Arun District Council
Arun Civic Centre
Maltravers Road
Littlehampton
West Sussex BN17 5LF
Planning General Enquiries
Tel: (01903) 737756 Fax: (01903) 730442
Dx: 57406 Littlehampton
Minicom: 01903 732765
e-mail: planning@arun.gov.uk
website: www.arun.gov.uk/planning

Our Ref: FP/32/19/PL
Your Ref:

Town & Country Planning Act 1990 (as amended)
Town and Country Planning (Development Management Procedure) (England) Order 2015
Application for Planning Permission

Development Conversion of part retail unit & storage area to form 9 No. residential units consisting of 3 No. 1 bed & 6 No. 2 bed dwellings & new access to rear.
Location 107 Felpham Way Felpham

Location Plan @1:1250

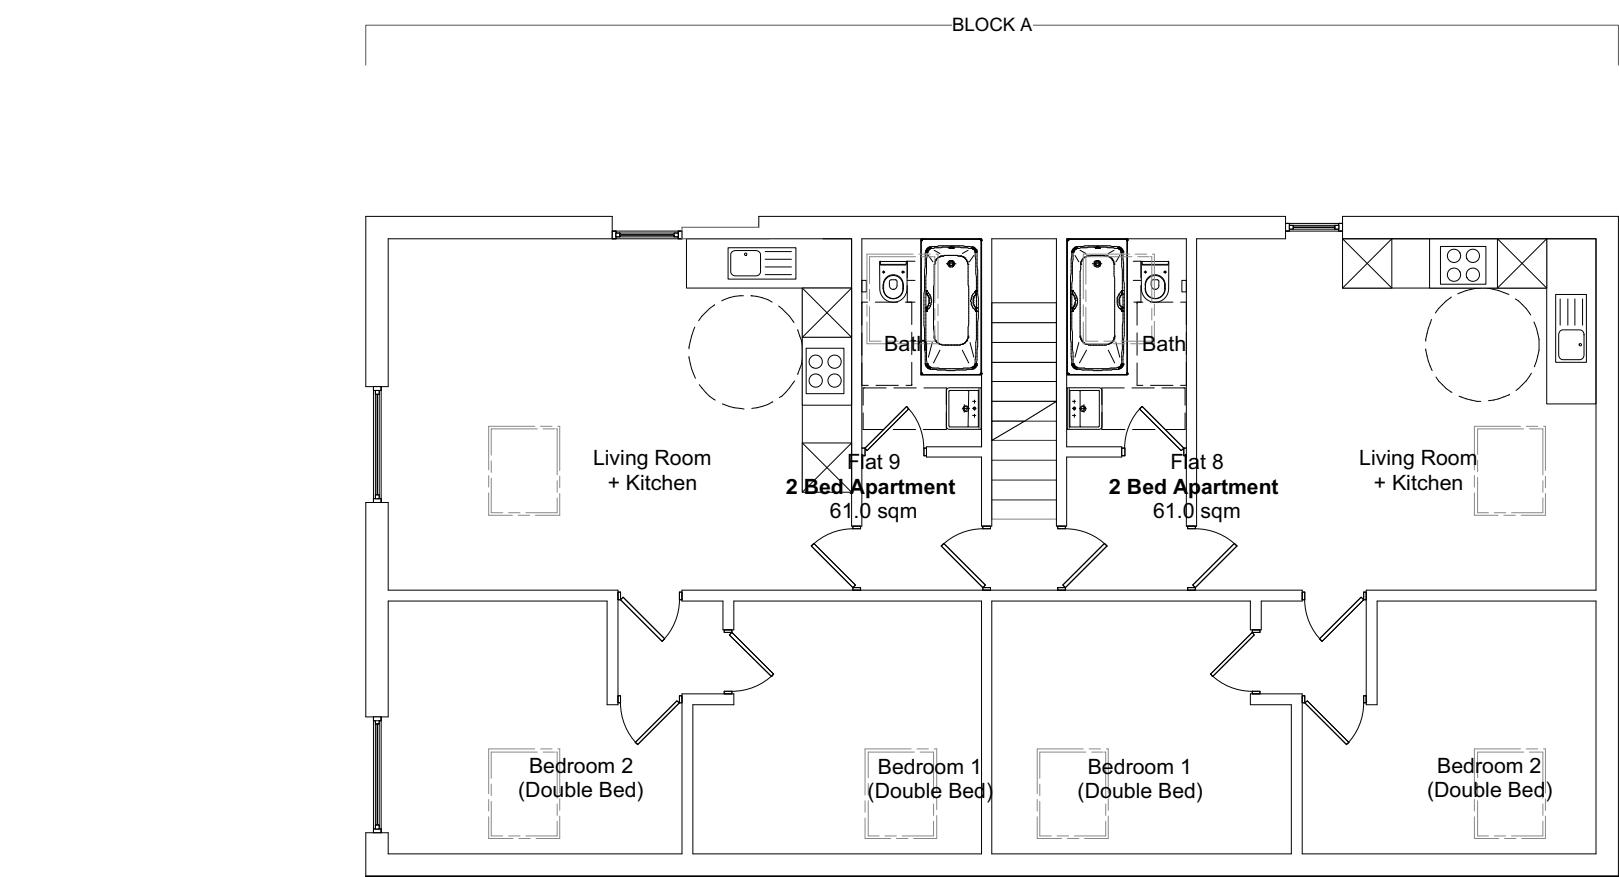
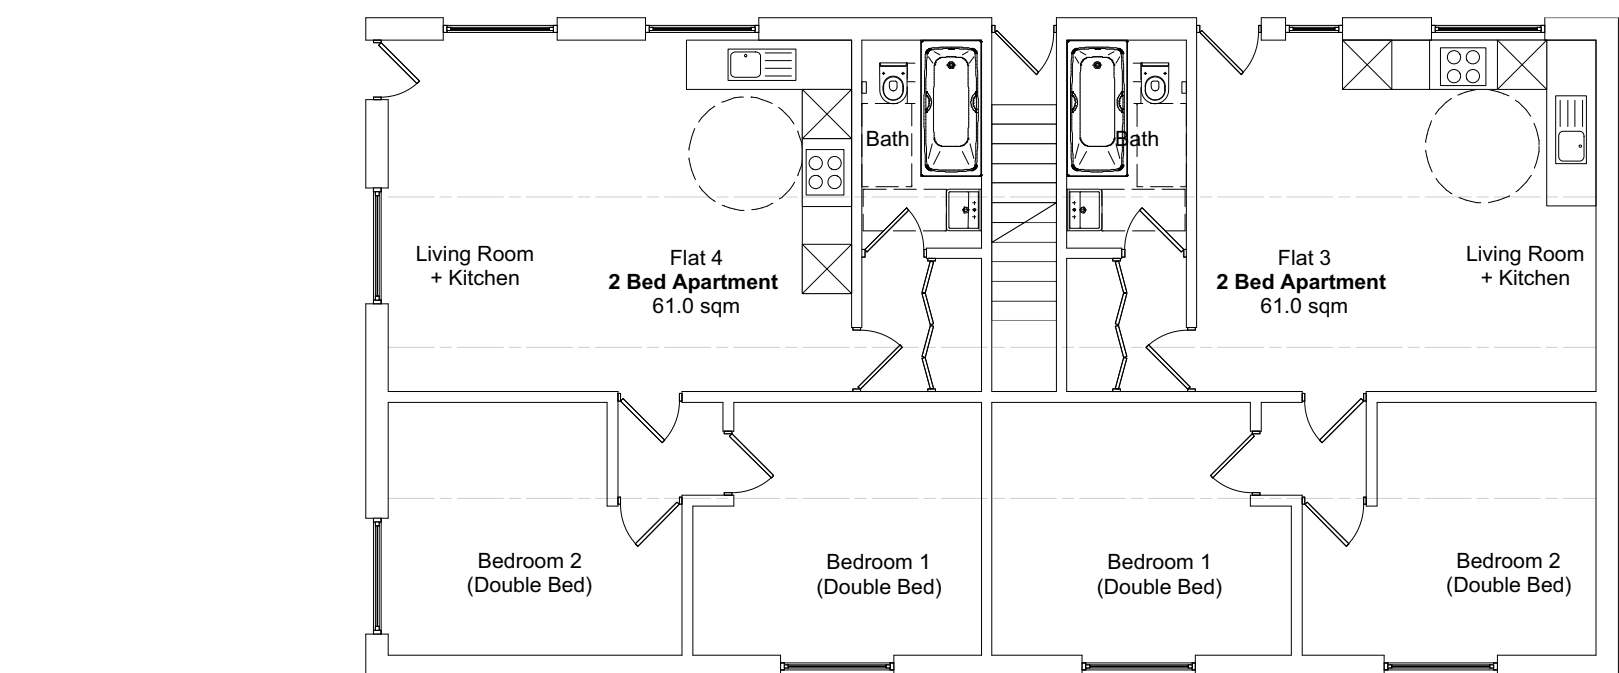
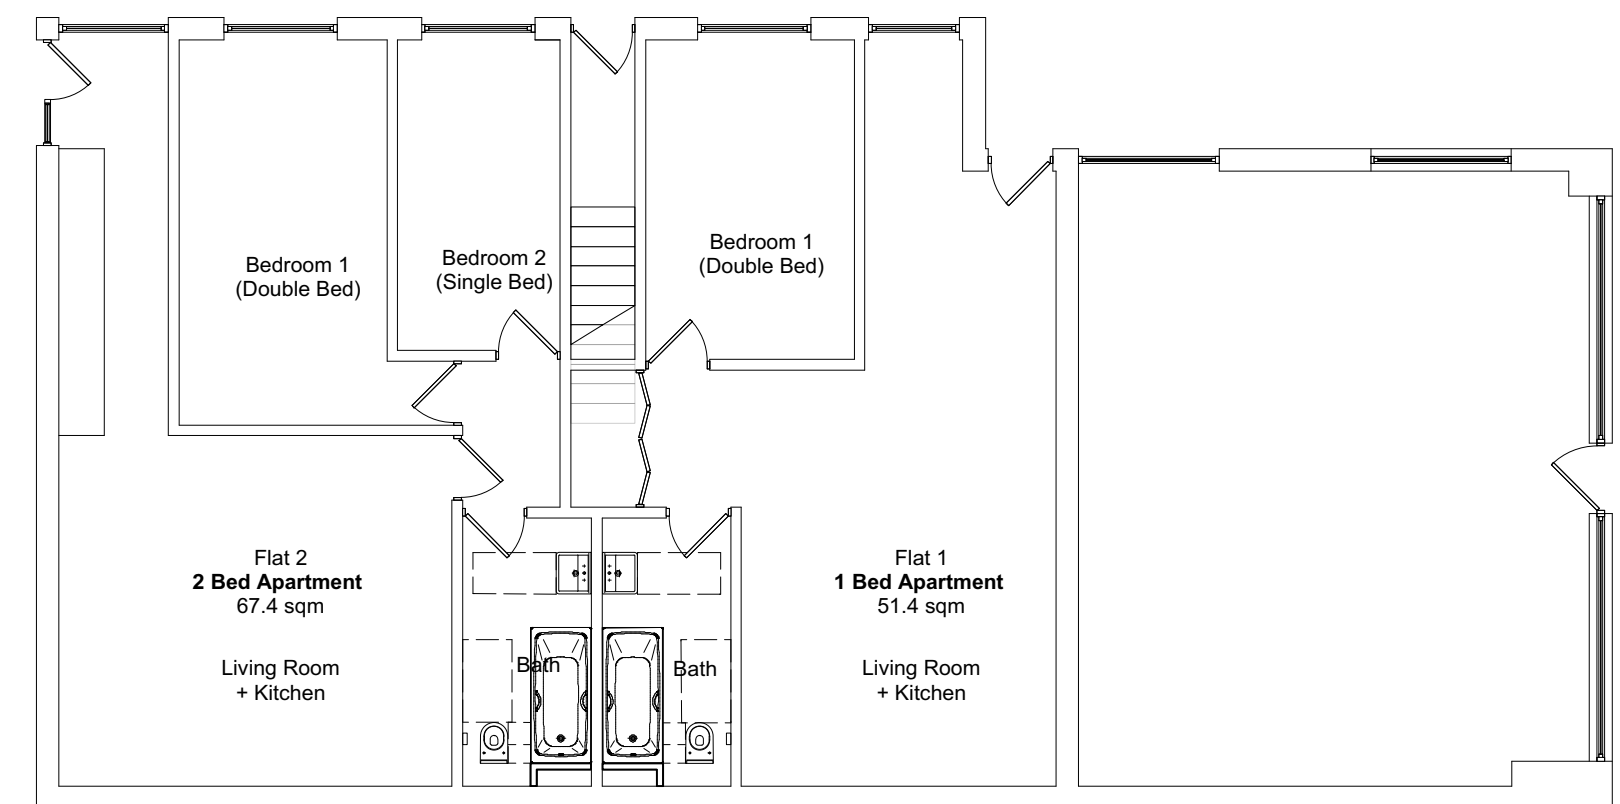
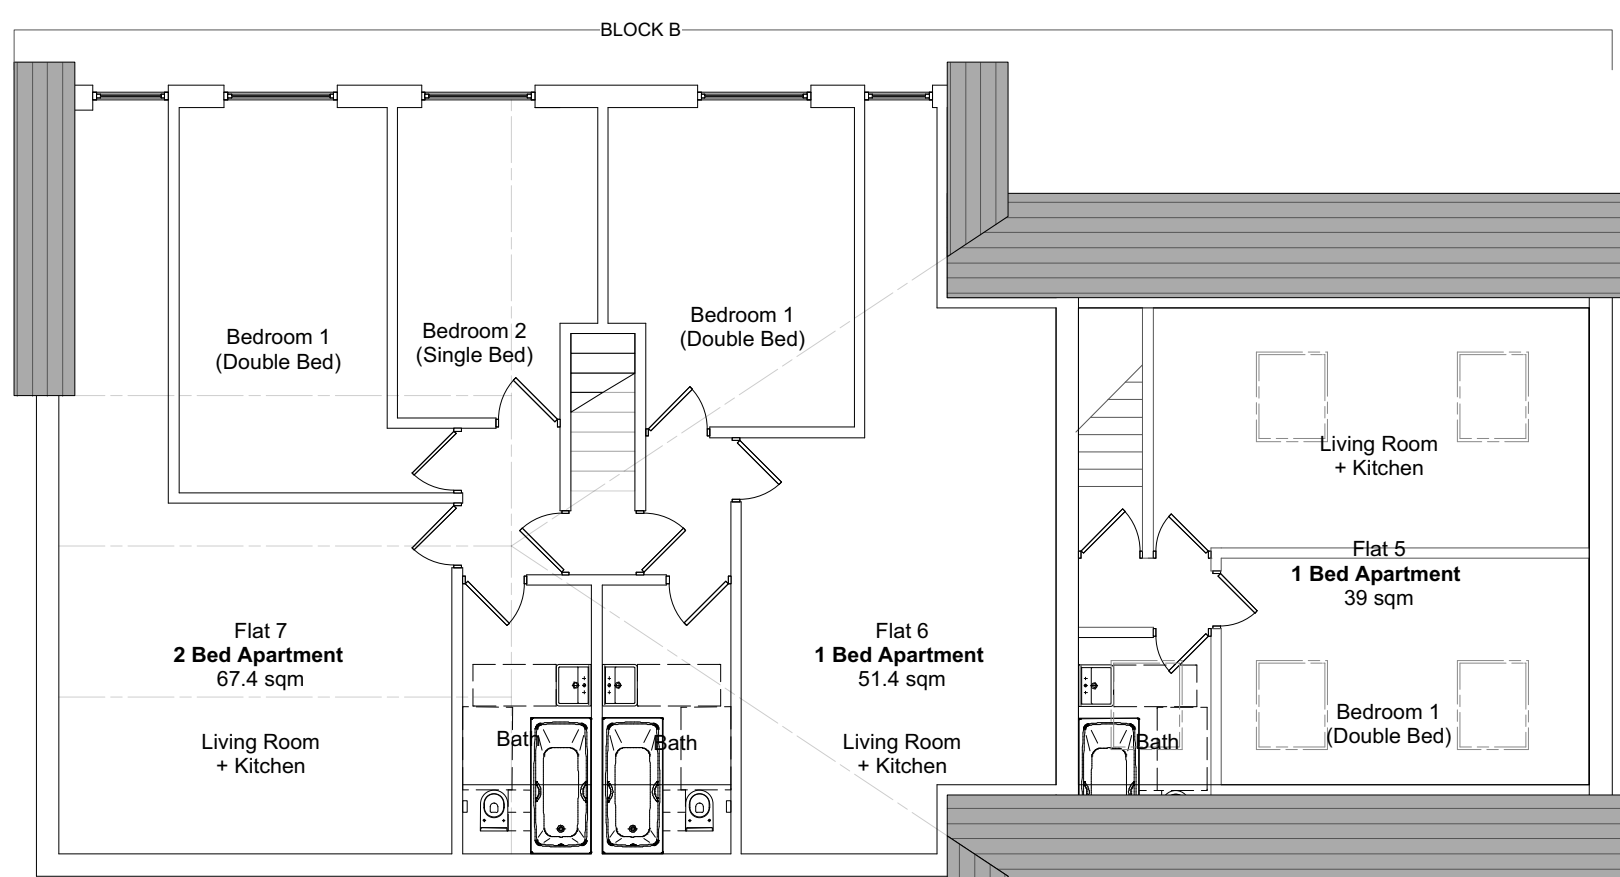
Location Plan Amend

Please show the position of the proposed buildings (for comparison).

GROUND FLOOR (Proposed) @ 1:100

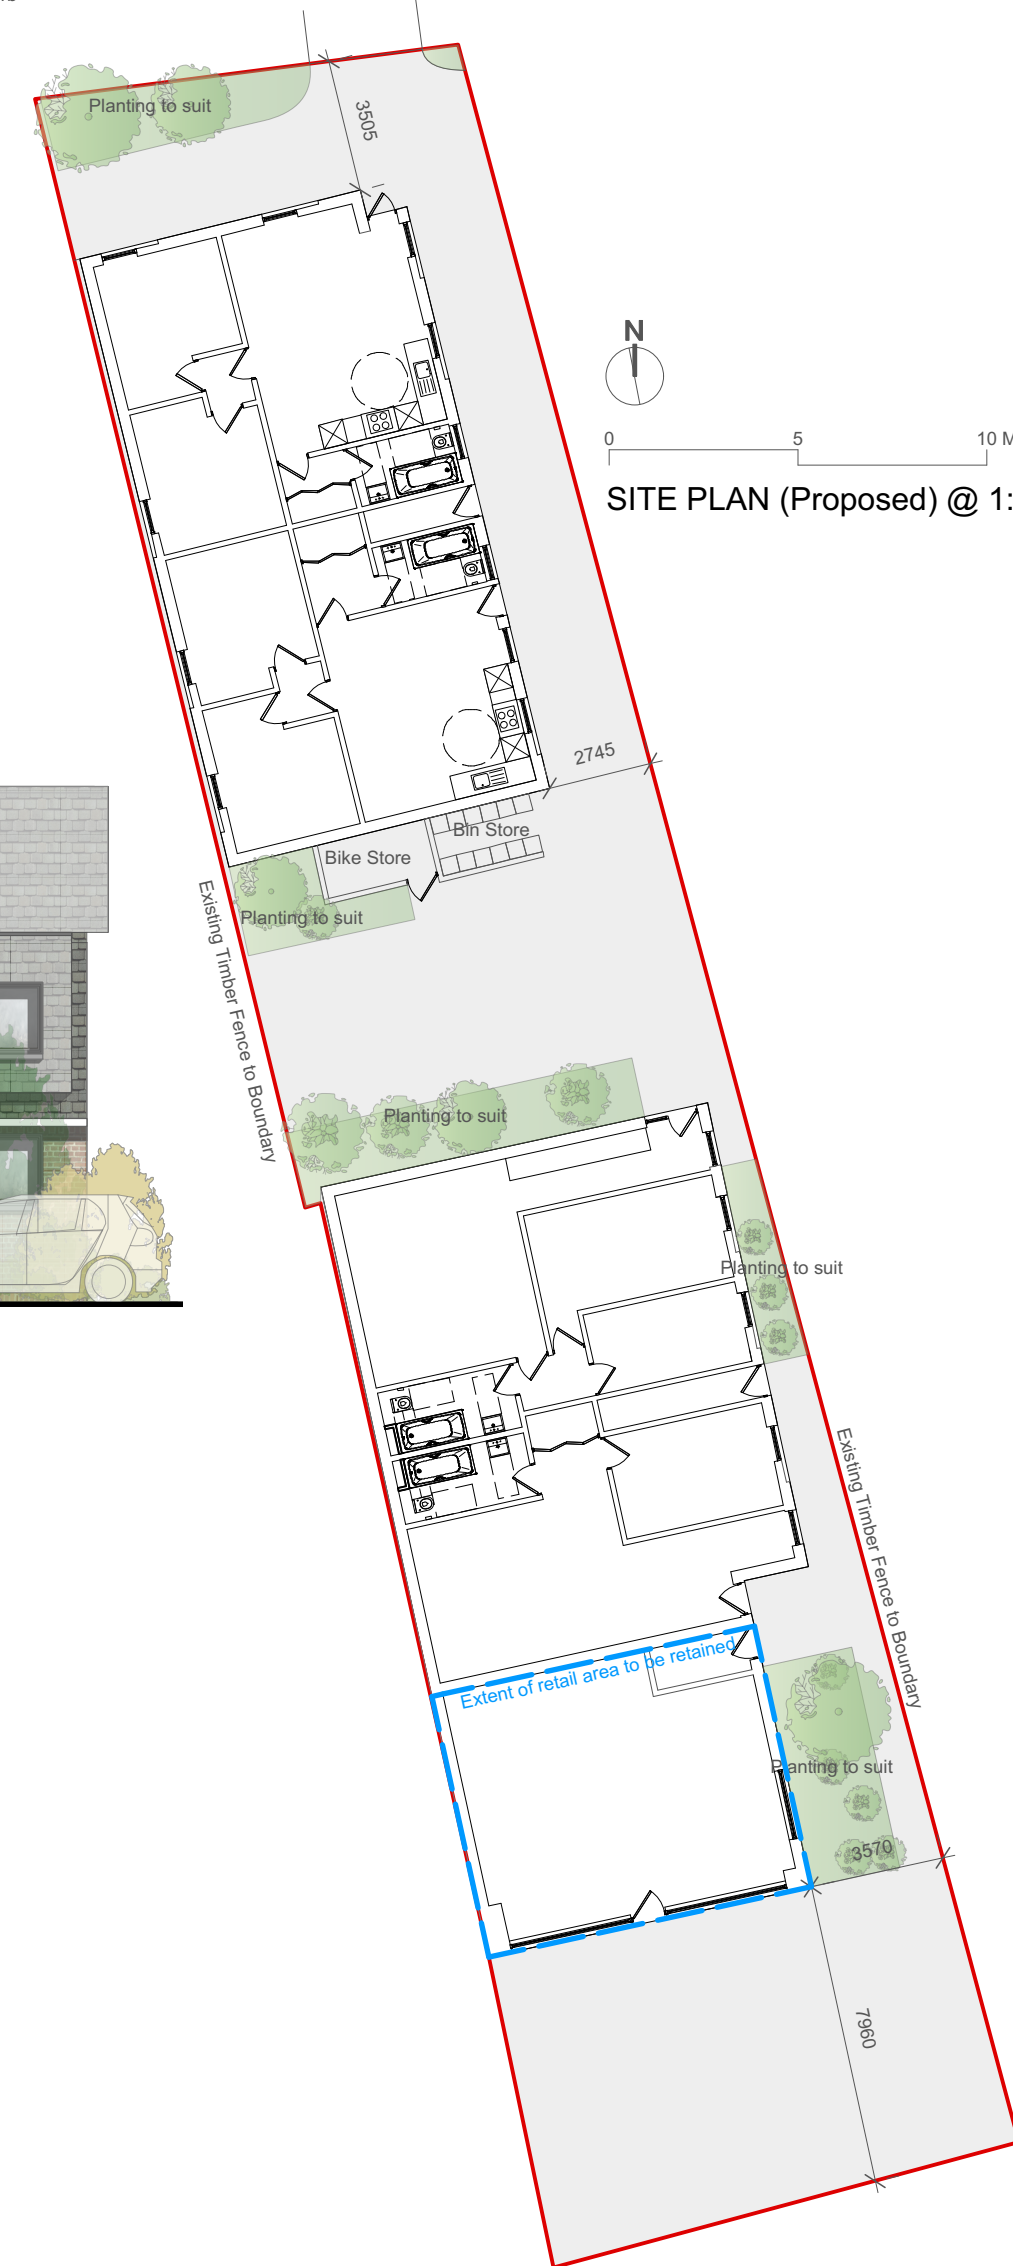
The block A ground floor plan and the proposed west elevation plan do not accord. Please amend accordingly.

NORTH ELEVATION-Street Scene (Proposed) @ 1:100

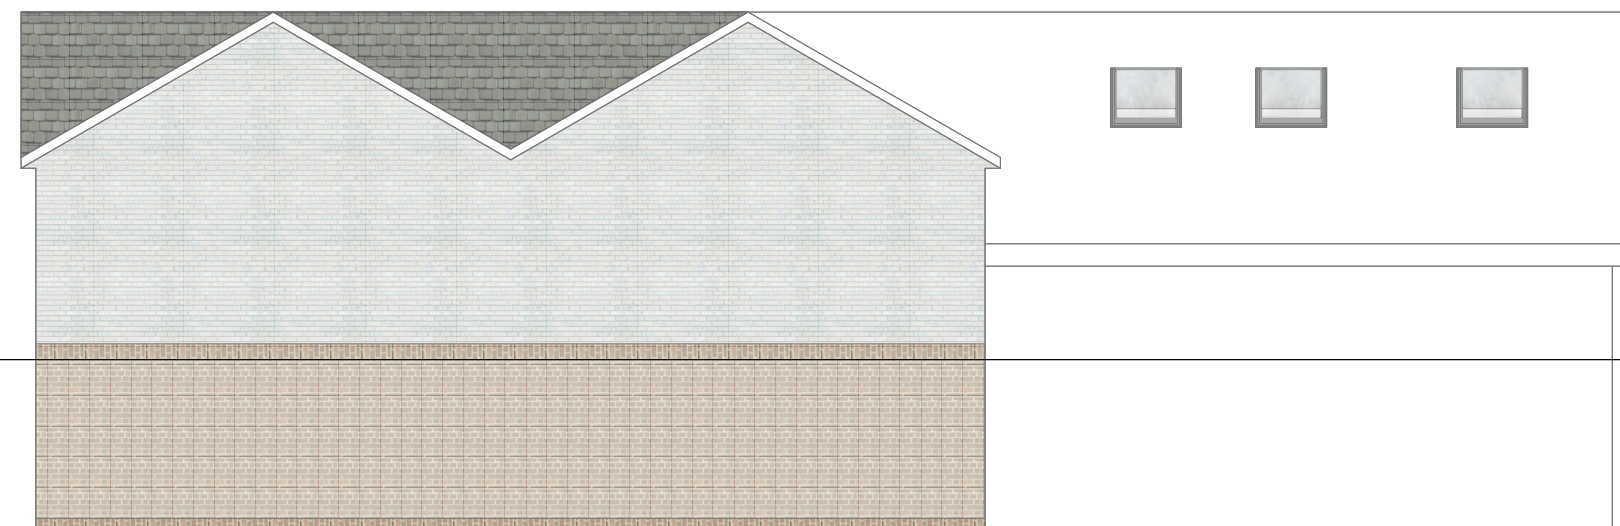
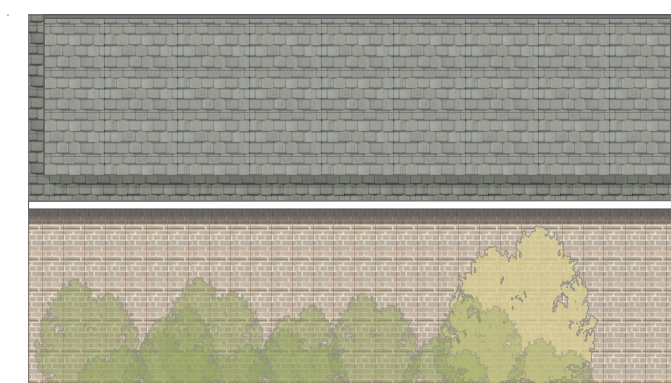
Please provide a street scene from Flax Mean.
